**Subject: Front Entry Plan Revisions
126-128 Danforth Street
Portland, Maine**

Attached please find drawings revisions (REV 1) to the design of front entry to 126 & 128 Danforth Street. Design incorporates comments from the Historic Preservation Board and meeting with Rob Wiener-Preservation Compliance Coordinator on August 23, 2017.

BUILDING LOCATED AT
126/128 DANFORTH STREET
PORTLAND, MAINE
FRONT ENTRY ROOF/DECK REPAIR
SECTIONS AND DETAILS

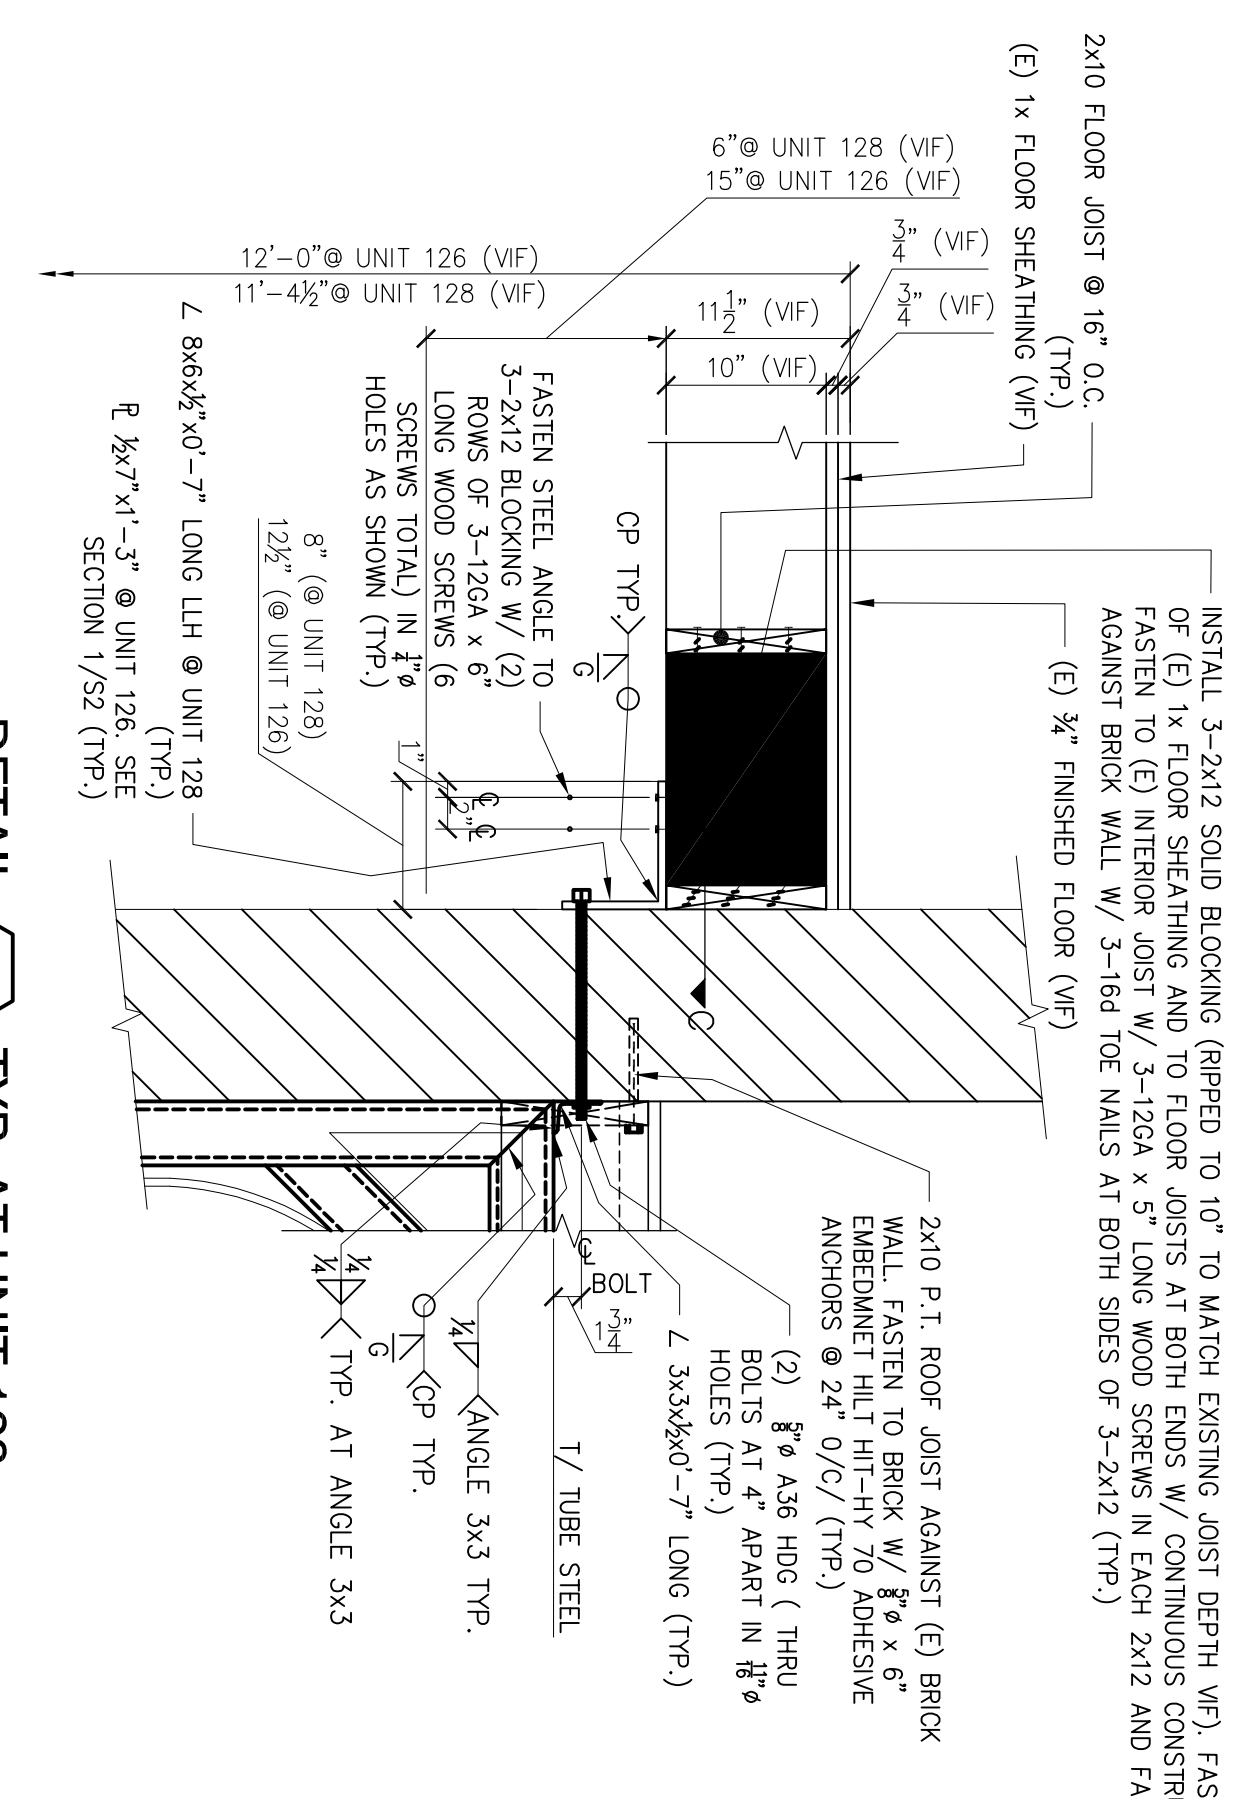
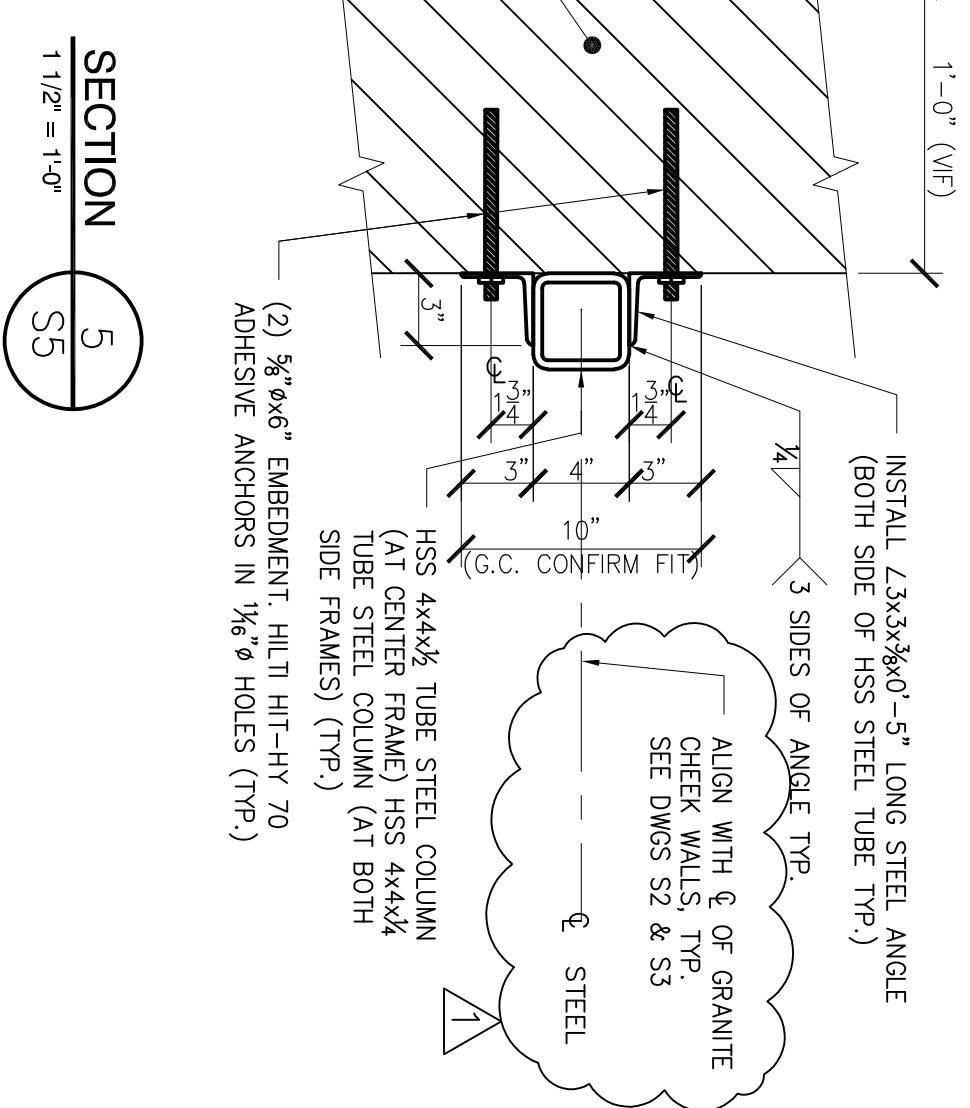
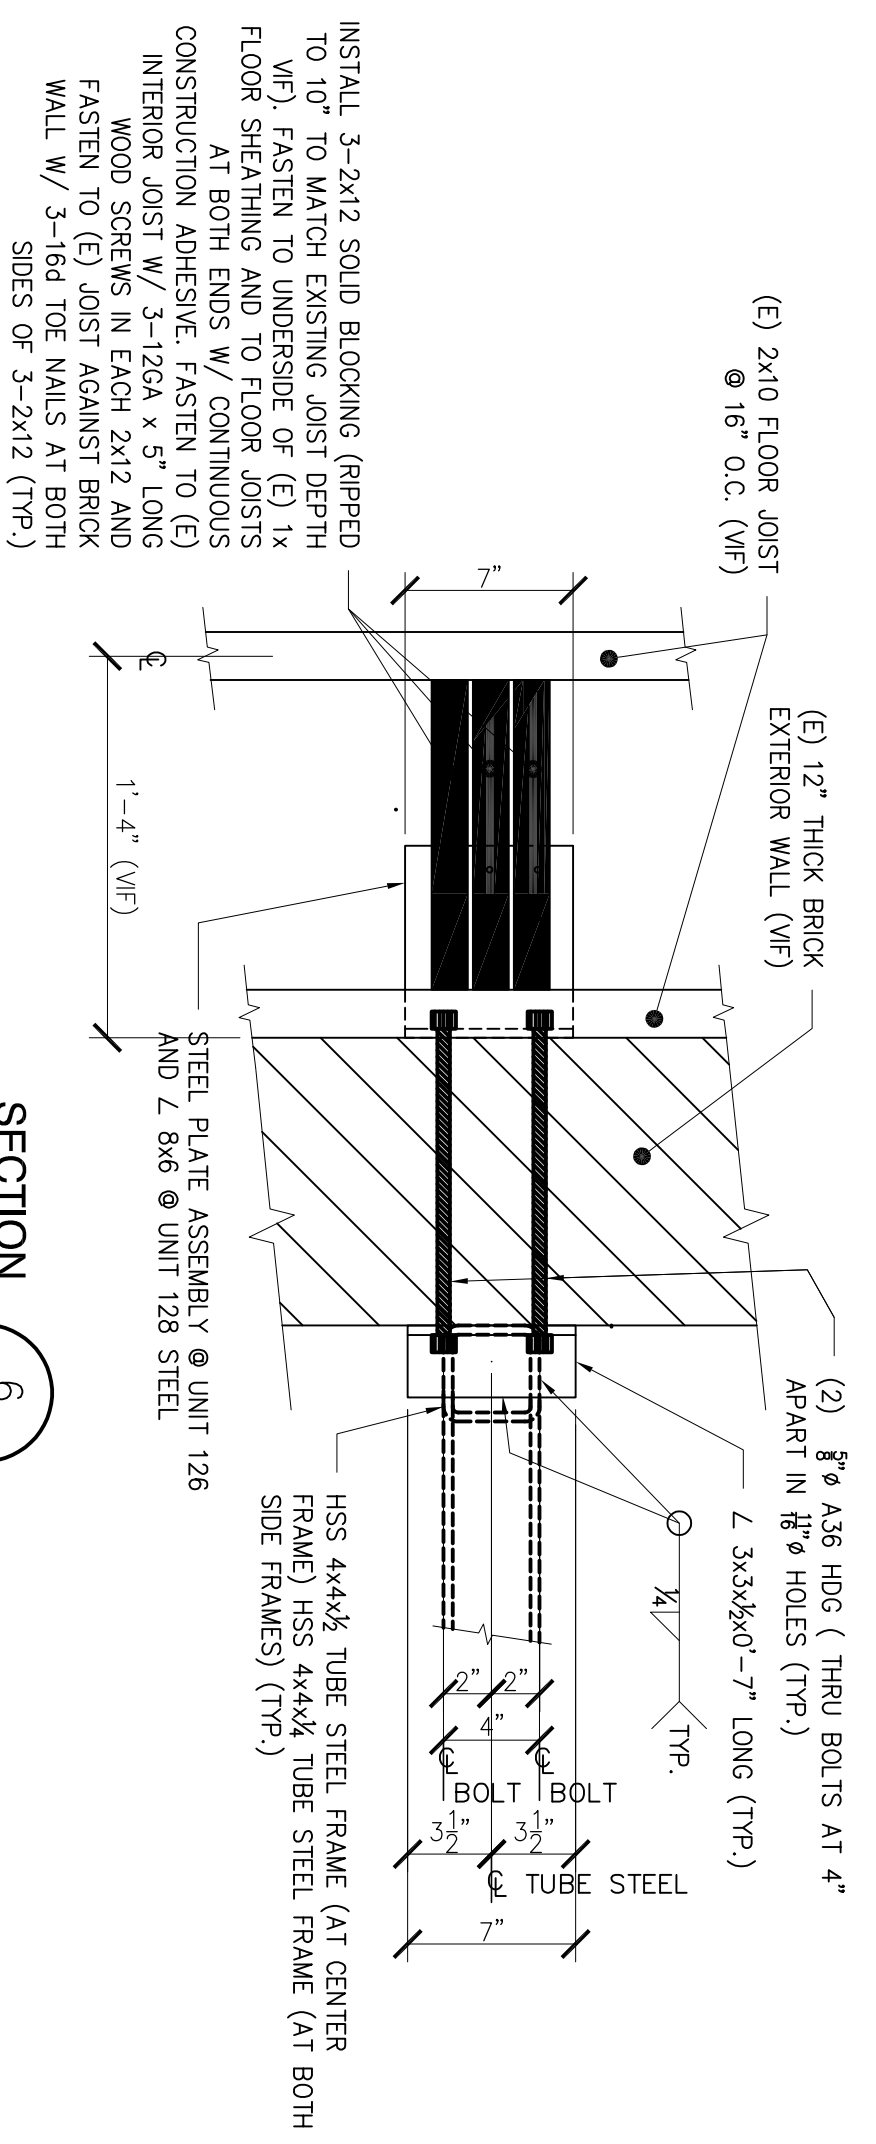
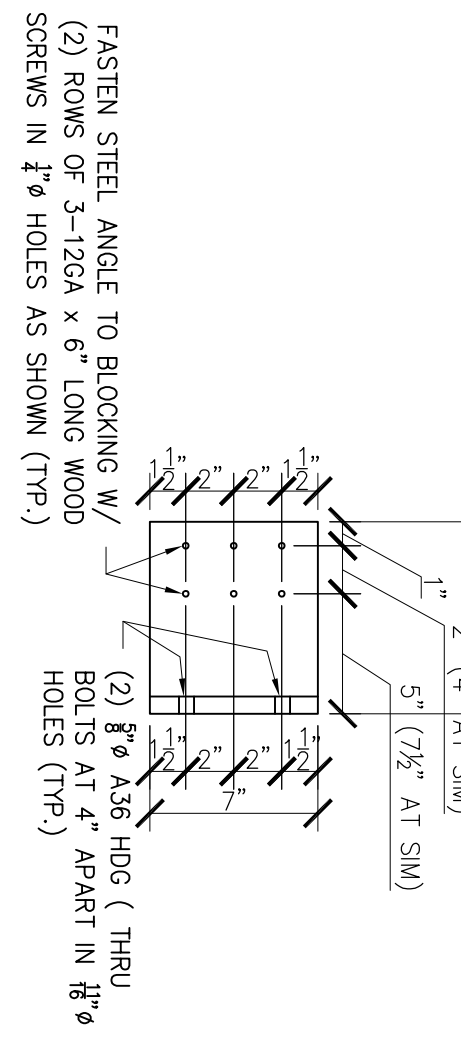
- a) Canopy Hood design to match existing dimensions, moldings and pattern.
- b) Ceiling mounted light fixtures with photo sensor (dusk to dawn) control, bulb type, wattage and color.
- c) Exterior emergency light remote heads located at canopy ceiling corner next to inside face of end carved wood brackets on each side. (2 req'd)
- d) Double entry doors with rased wood moldings at each residence address. (4 doors req'd)
- e) Vinyl address lettering applied to clear glass transom on each side.
- f) Colors for existing windows, entry doors, moldings, gutter, carved brackets, and handrails indicated.
- g) Tenant Mailbox type, dimensions, location, and color provided.
- h) Cleaning of existing painted granite surfaces.
